Consultation Response from KC, Highways Development Management
2023/92156 120, Staincliffe Road, Westborough, Dewsbury, WF13 4RP
Alterations to convert retail lower ground and ground floors to two flats
Date Responded: 01/02/2024. Responding Officer: D. Stainsby Responding Ref: K14-10SW/3

RECOMMENDATION

No Objection subject to a dropped crossing being provided on Staincliffe Road

PROPOSED LOWER GROUND FLOOR PLAN

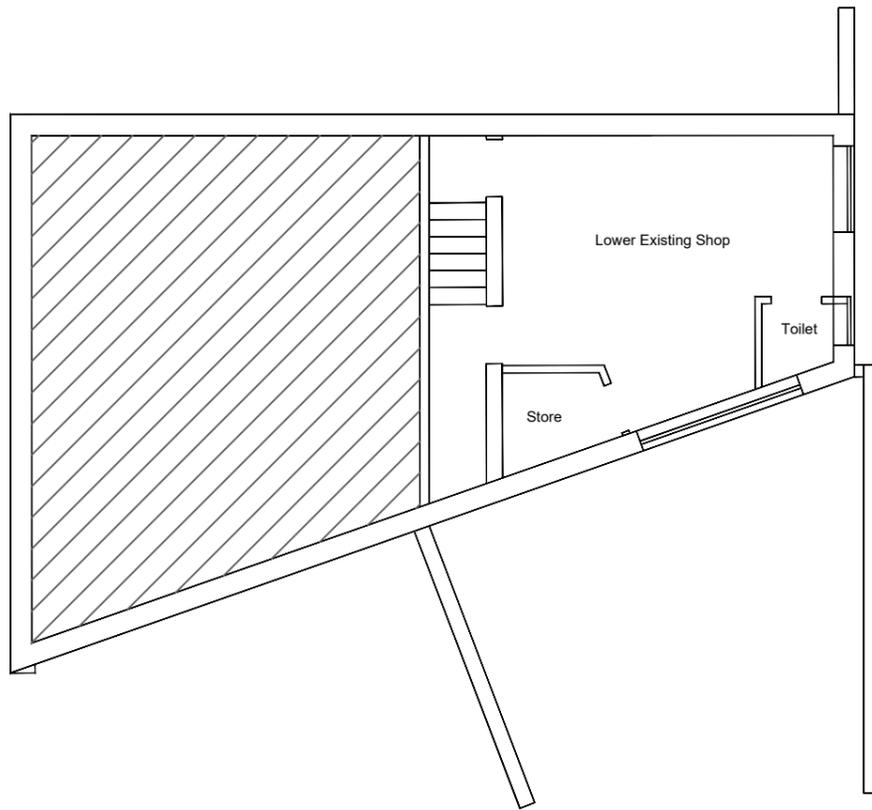
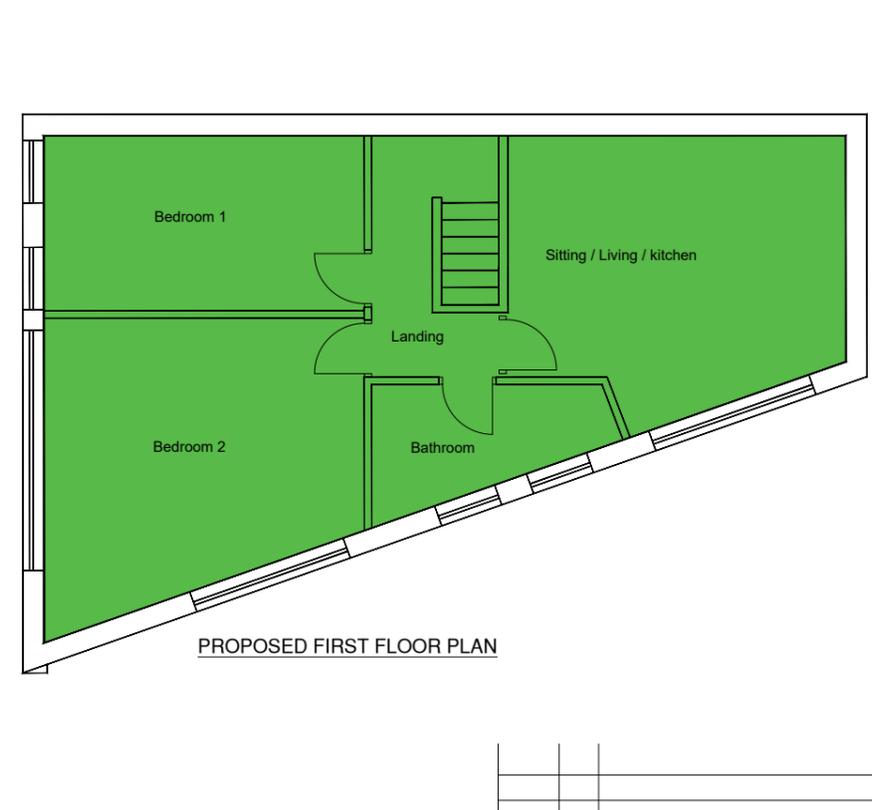
There is a further space on lower ground to the west of the building.

Although there is provision for off street parking on the north and west frontages of the site, there is only one dropped kerb provided on Green Lane to allow vehicle access onto these areas.

An additional dropped kerbs should be provided at the vehicle access onto Staincliffe Road and the adjacent access to lower ground floor.
